FW: SUB19-002 (SEP19-005/Requirement For No Onsite Open Space/Lack of Tree Regulation)

From: Dan Thompson <danielpthompson@hotmail.com>
Sent: Friday, December 22, 2023 2:58 PM
To: jeff.thomas@mercerisland.gov <jeff.thomas@mercerisland.gov>
Cc: jessi.bon@mercergov.org <jessi.bon@mercergov.org>; council@mercergov.org <council@mercergov.org>
Subject: SUB19-002 (SEP19-005/Requirement For No Onsite Open Space/Lack of Tree Regulation

This is the application for a long plat on the old Boys and Girls Property the MI school dist. donated to the BGC in 1984 for recreation. I have a post on ND addressing this. https://nextdoor.com/p/mSBjhfBt7hsB?utm_source=share&extras=NDEONTk4OQ%3D%3D&utm_campaign=1703284690389

JOB NO : 19007
SHEET 3 OF 3

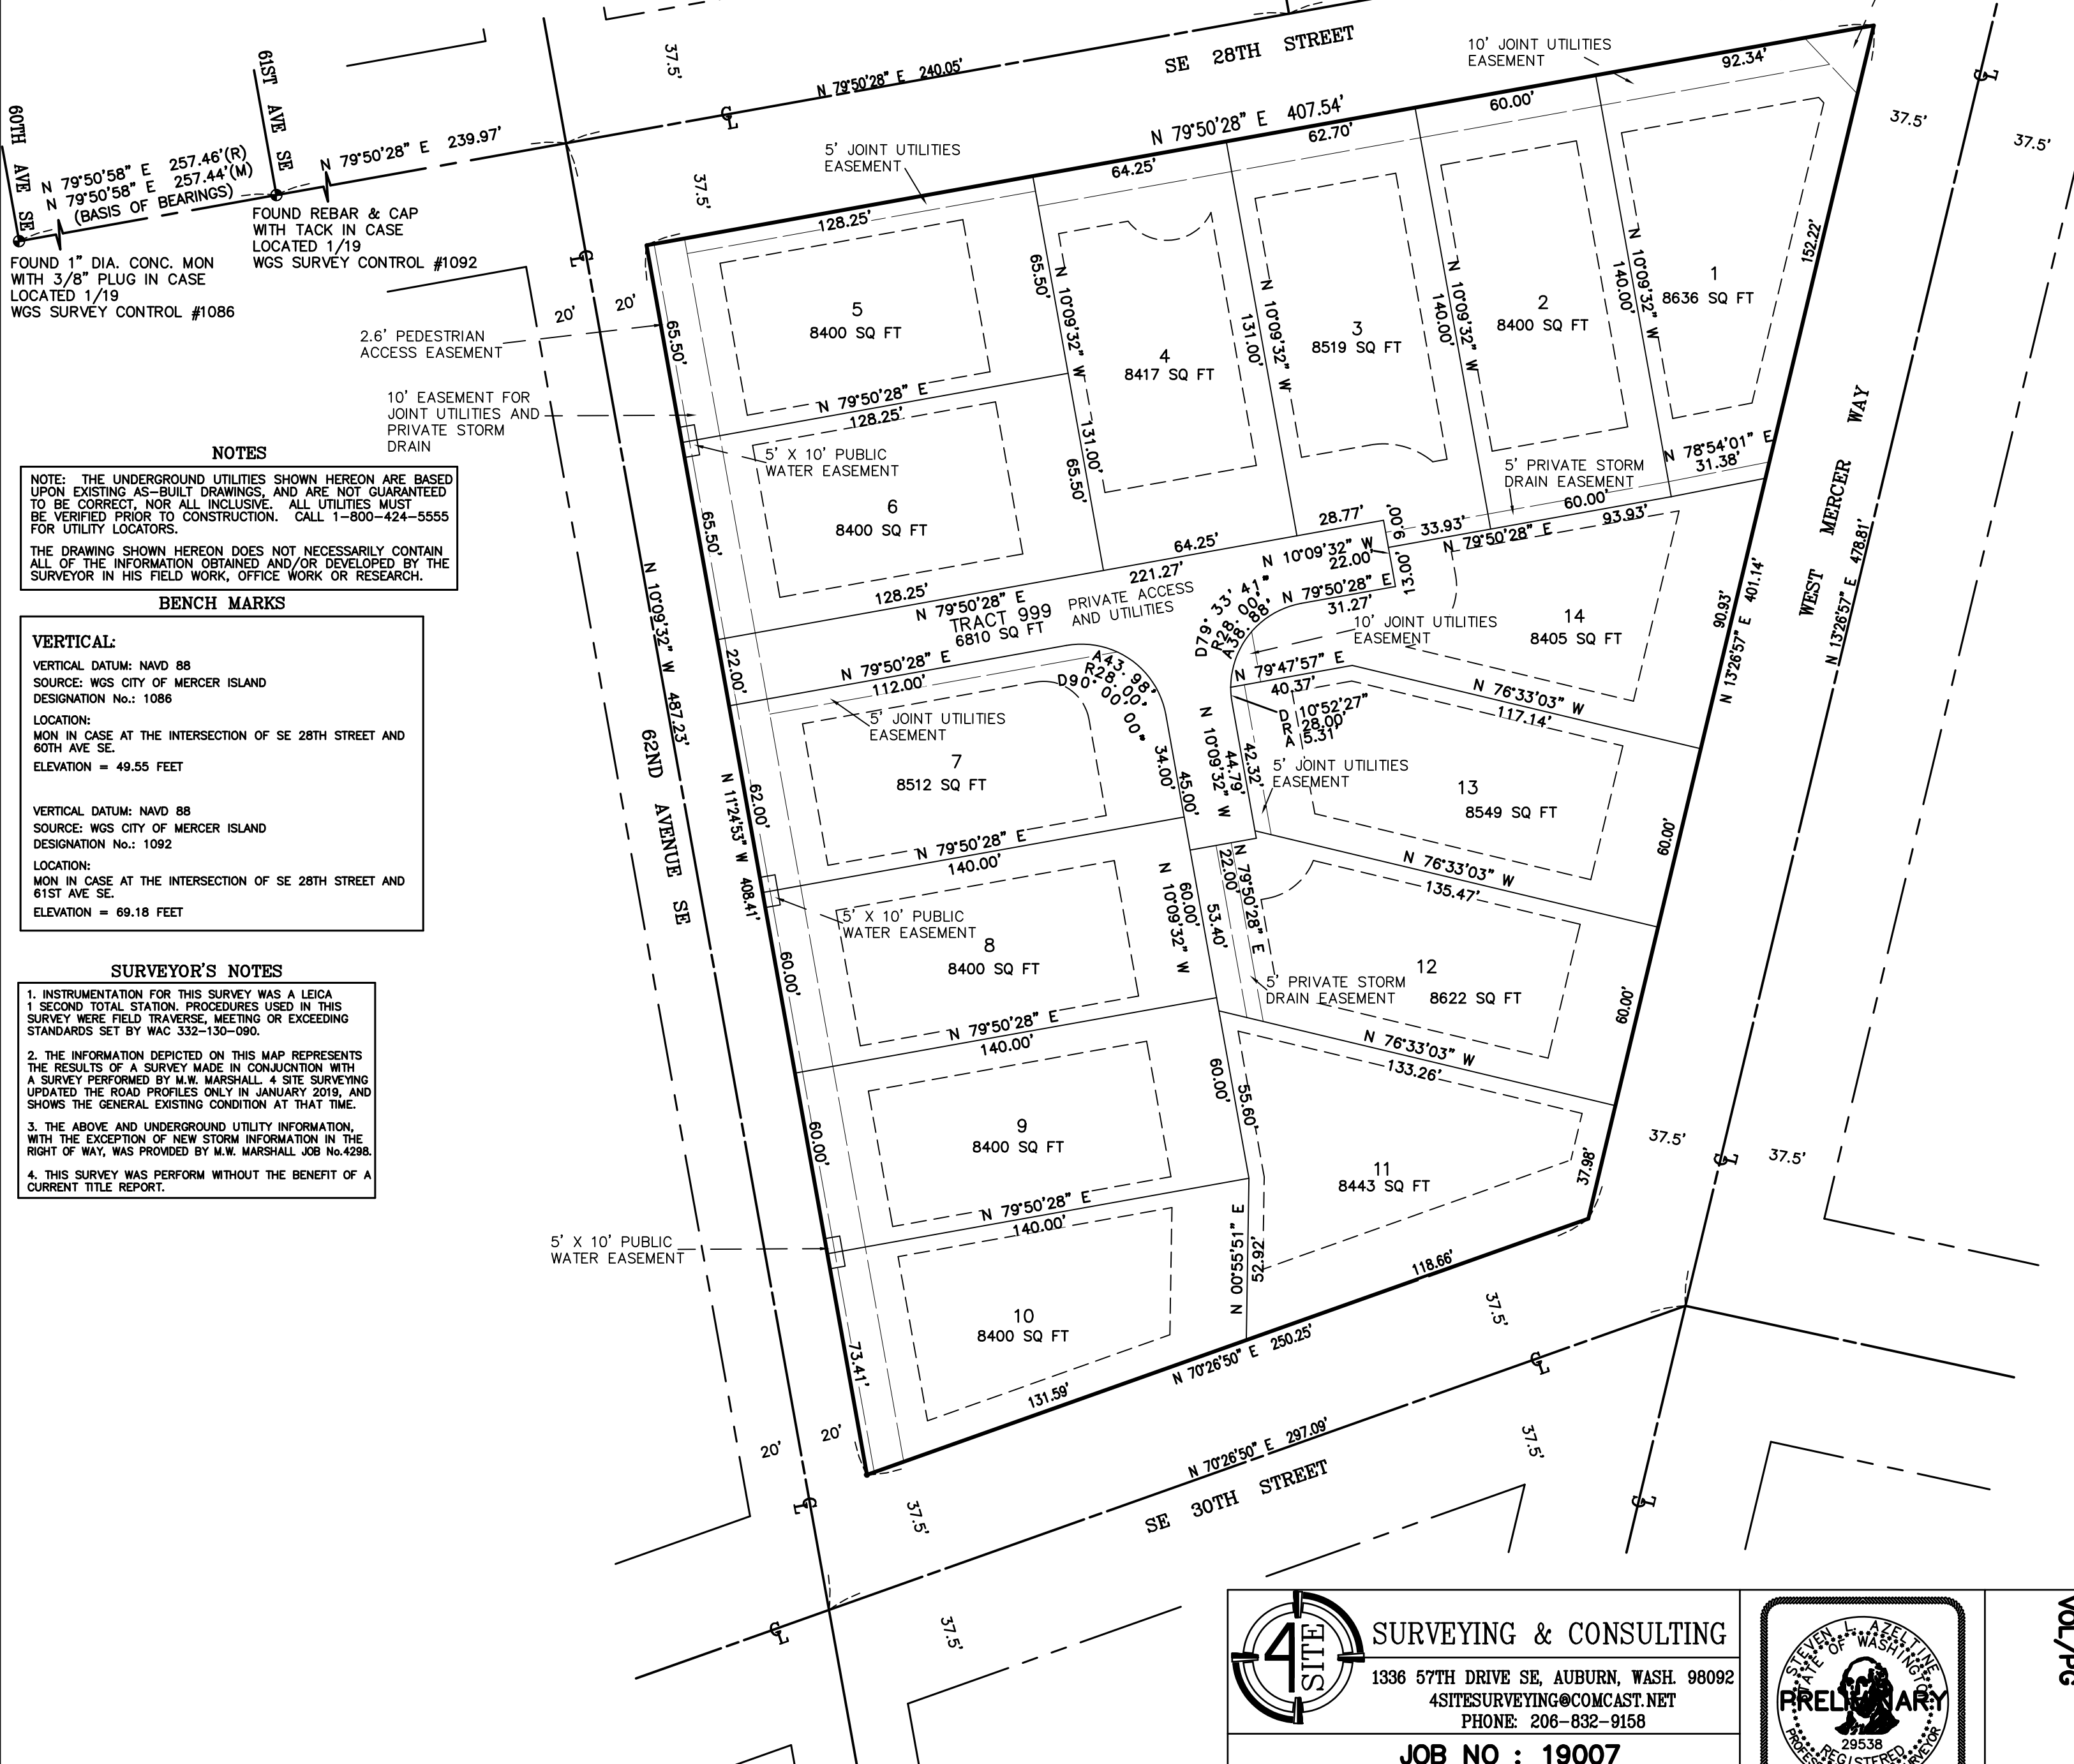
Here is a site map for the proposed 14 plat long division. [12. pin2174502425-supp-platmap.pdf \(mercergov.org\)](#). The only "open space easement" listed on the map is the tiny triangle in the upper right-hand corner.
